**Patterson Britton  
& Partners Pty Ltd**

## **SURVEY STREET, LENNOX HEAD – WATER MANAGEMENT**

This letter addresses the water management issues raised in the Department of Planning (*DoP*) letter dated 4 December 2006 and the related submissions with respect to the Environmental Assessment for the above residential subdivision.

Title
TYPICAL ROAD 2 PROPERTY ACCESS THROUGH RETAINING WALL

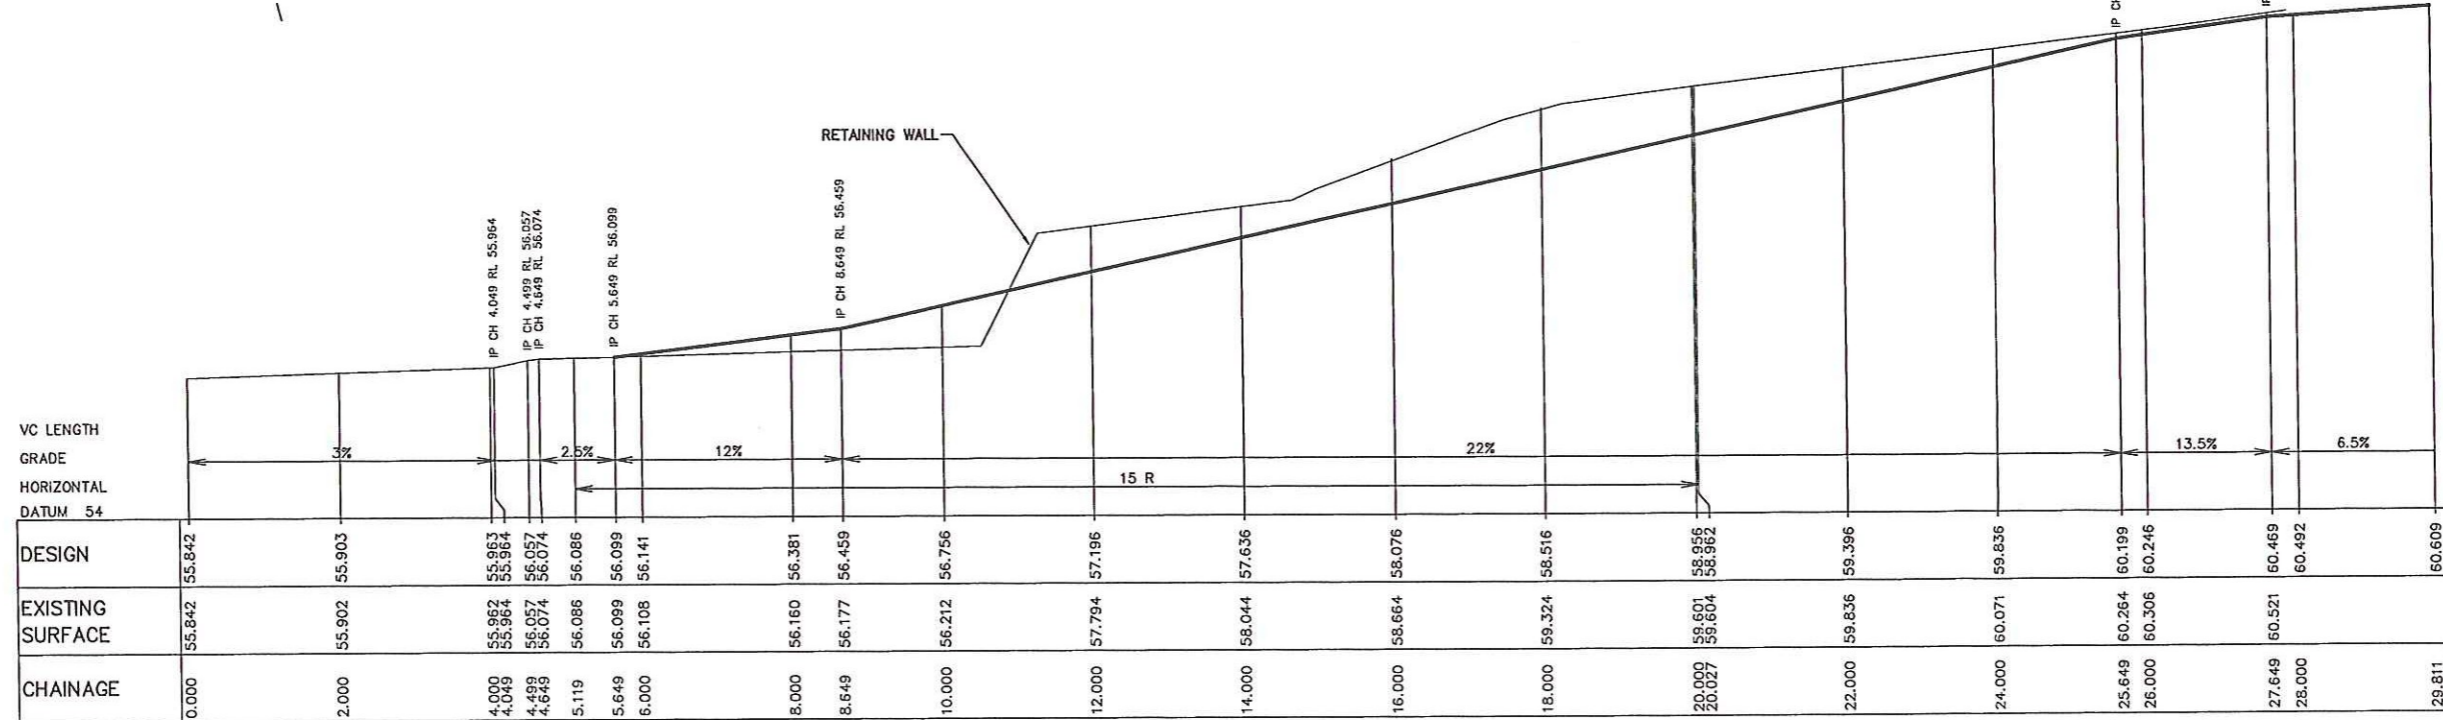
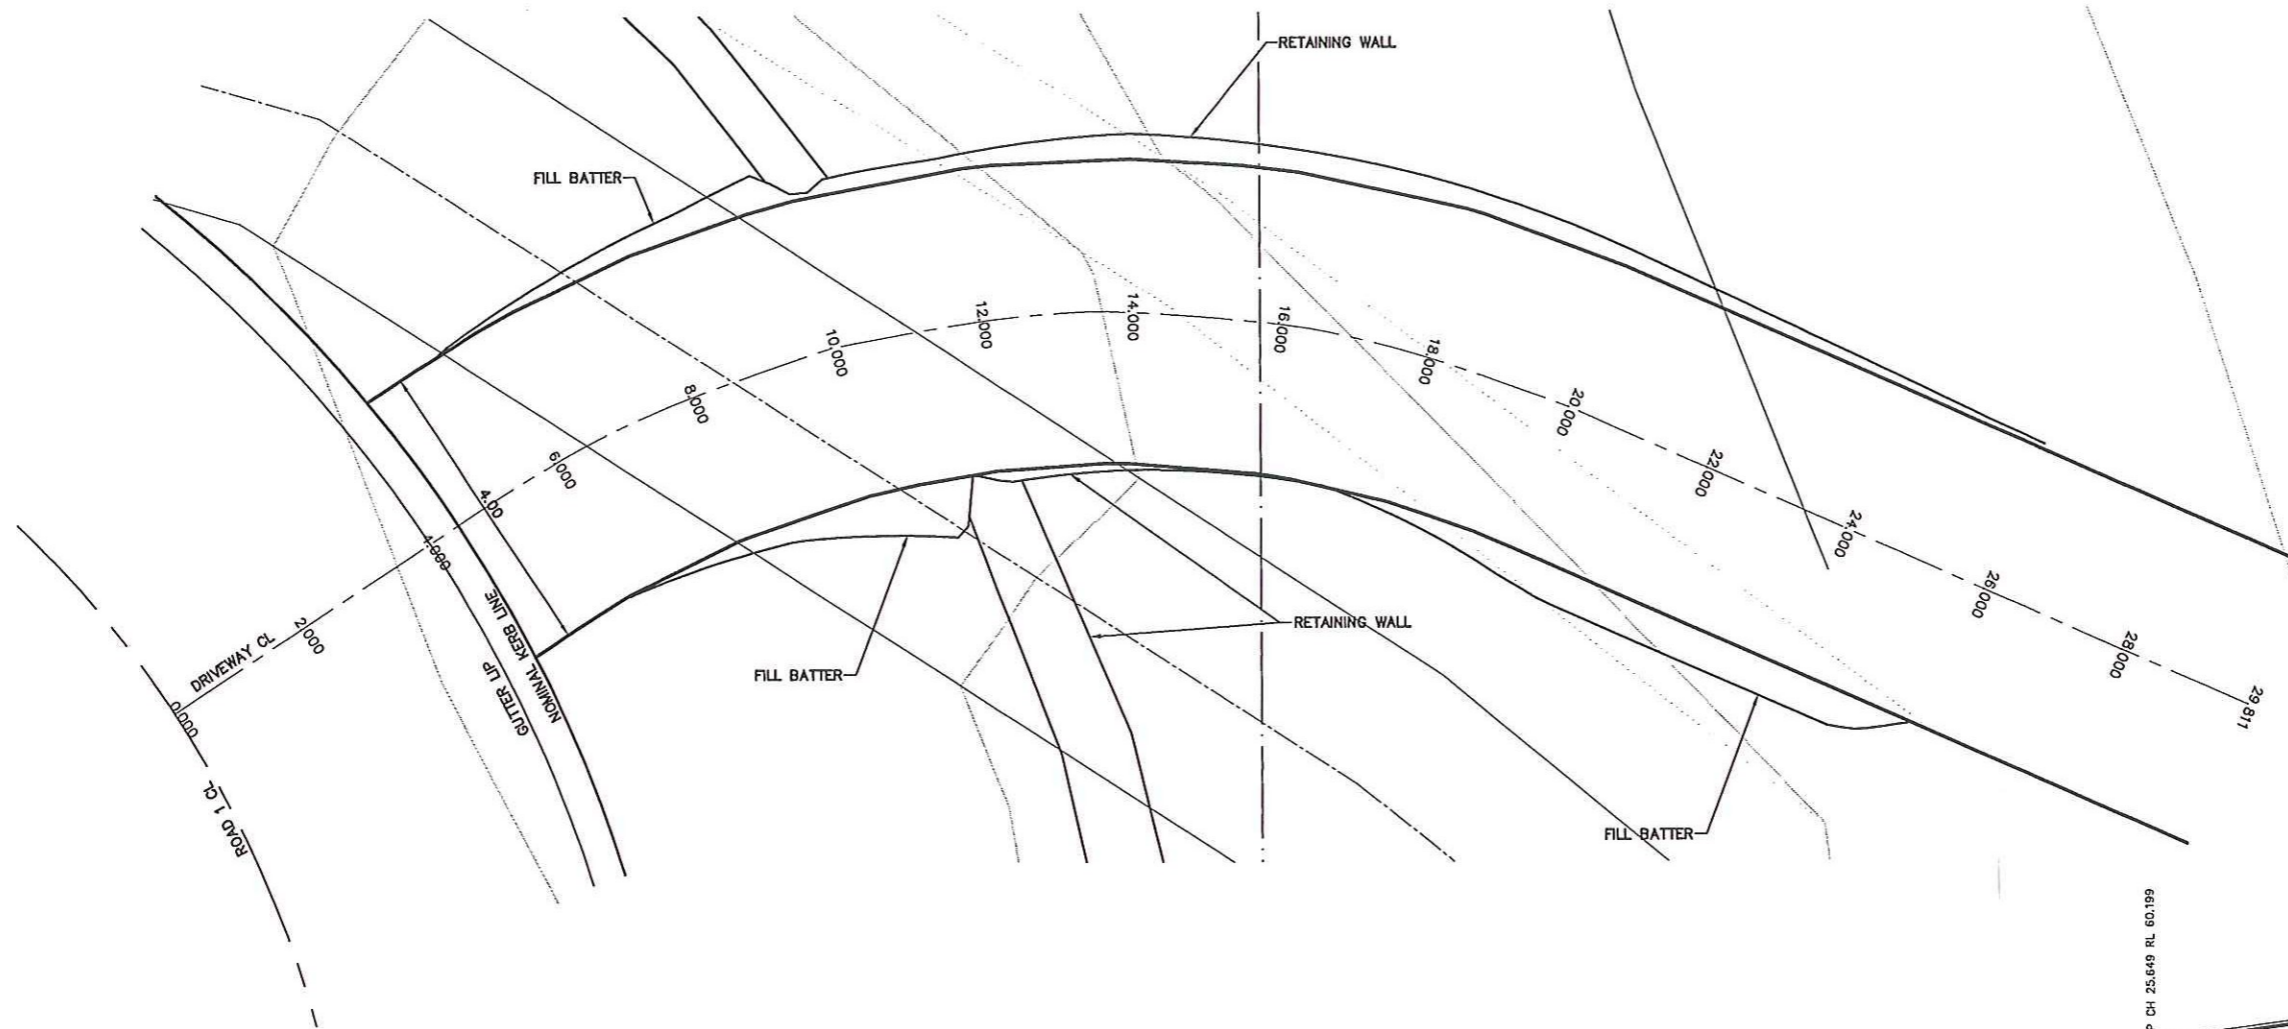
Driveway construction has been addressed for lots with land higher than the proposed roads. It was proposed that for Lots 12 (*southern dwelling*) 37, 40 to 44 that driveways and garages would be constructed on suspended structures as per the proposed houses. This form of construction for steep lots is typical.

The applicant has committed to further refinement of the Road 1 design at the construction certificate stage to explore the potential to lower the pavement levels to minimise the height of these suspended structures.

FIGURE 1

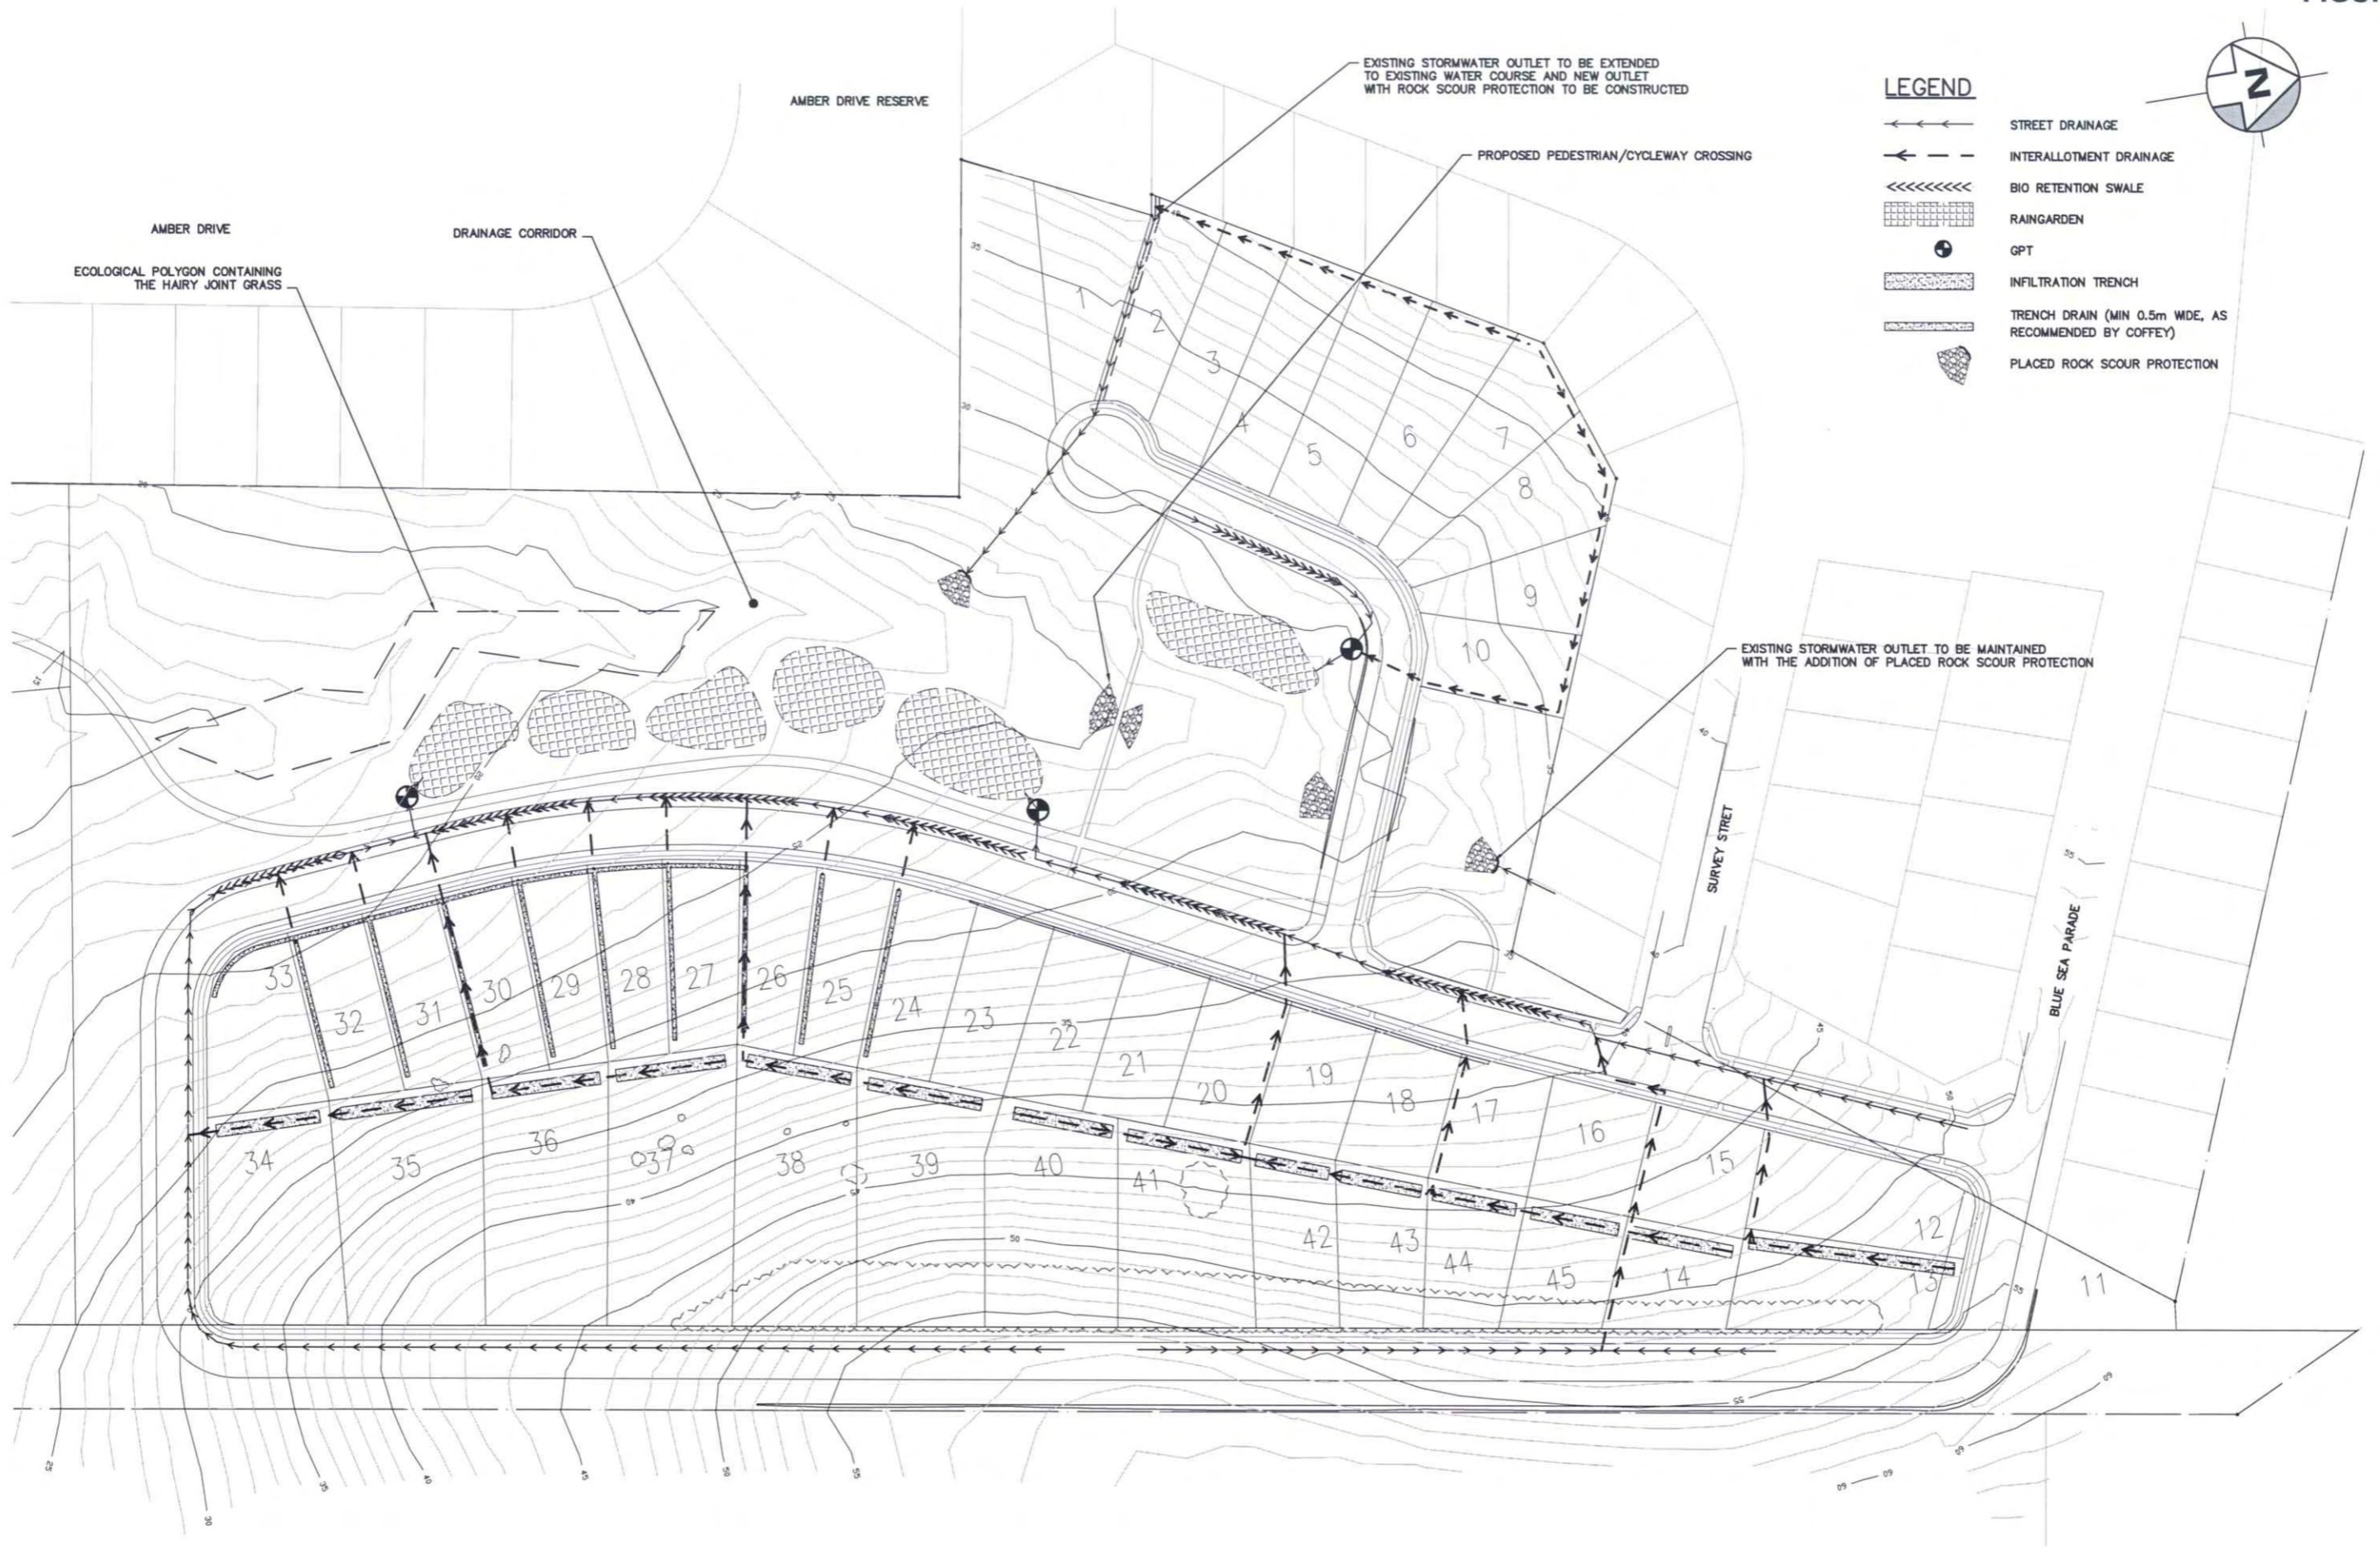
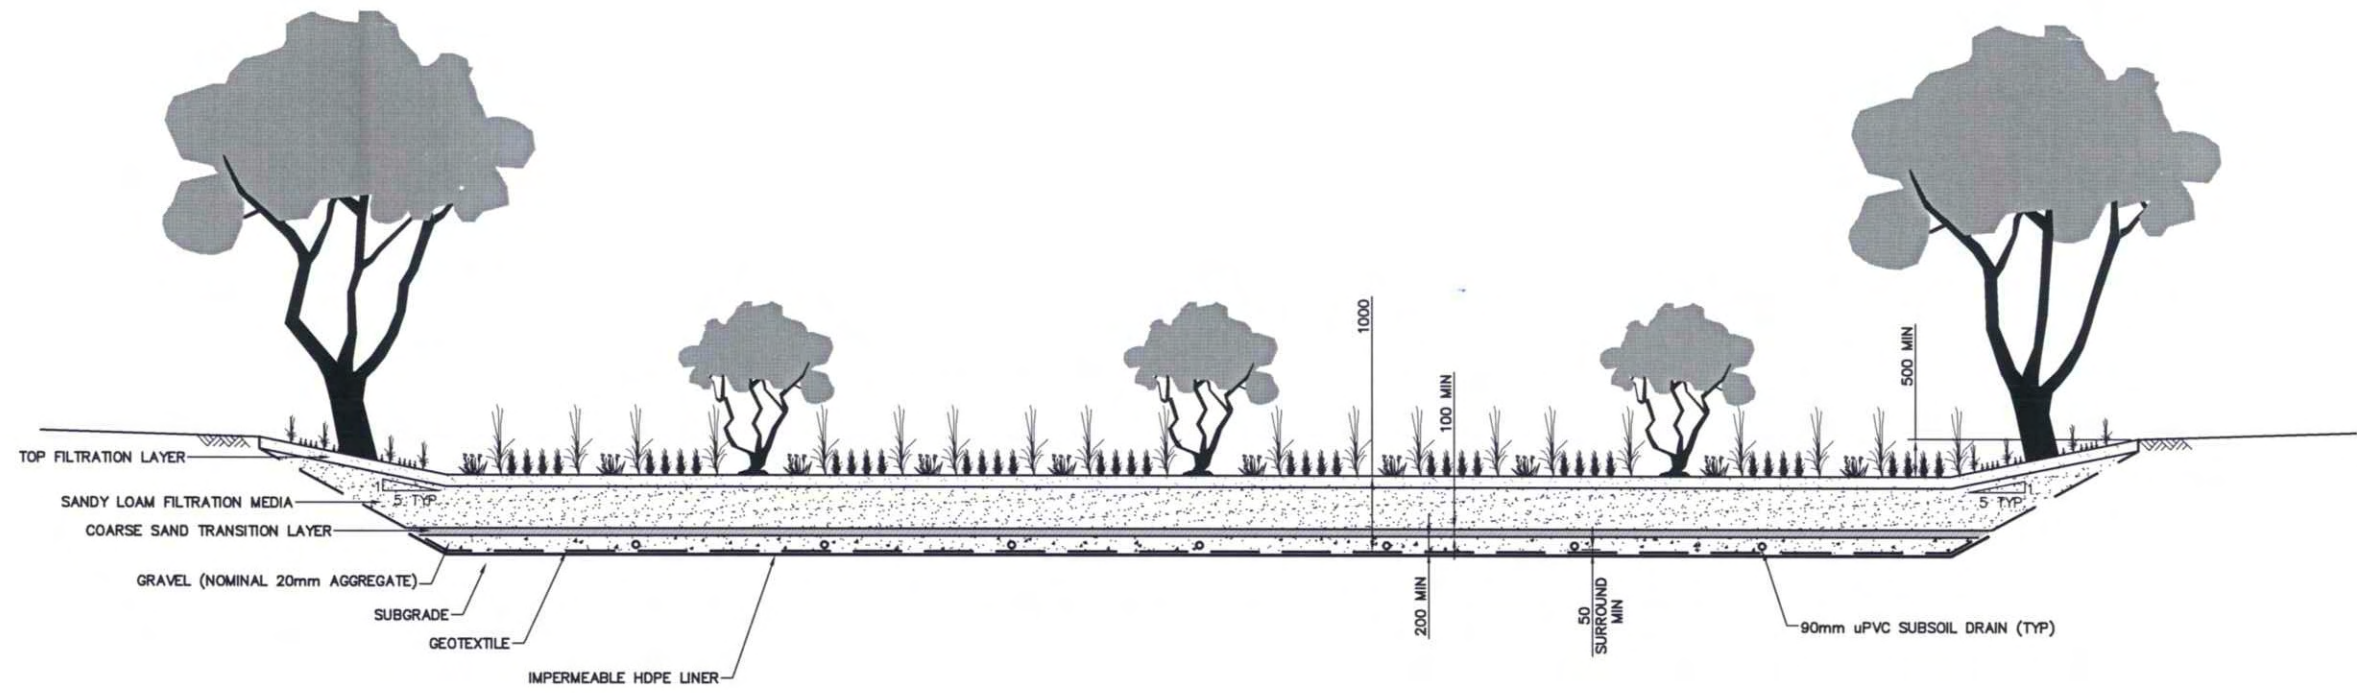
1. The runoff collection drains (*previously called infiltration trenches*) would not promote infiltration into subsoils. They will direct collected surface runoff into the interallotment pipe drainage system. Runoff from houses and paved areas will be discharged directly to the interallotment pipe drainage system not to the runoff collection drains. Coffeys have confirmed that this drainage system would not adversely impact on slope stability.

6. All drainage connections have been clarified in the attached **Figures 1 to 3**. The low flow from the raingardens would be discharged to the seepage distribution trench gravel drain. This would permit a slow and evenly distributed overflow and seepage to the creek which would not cause scour.
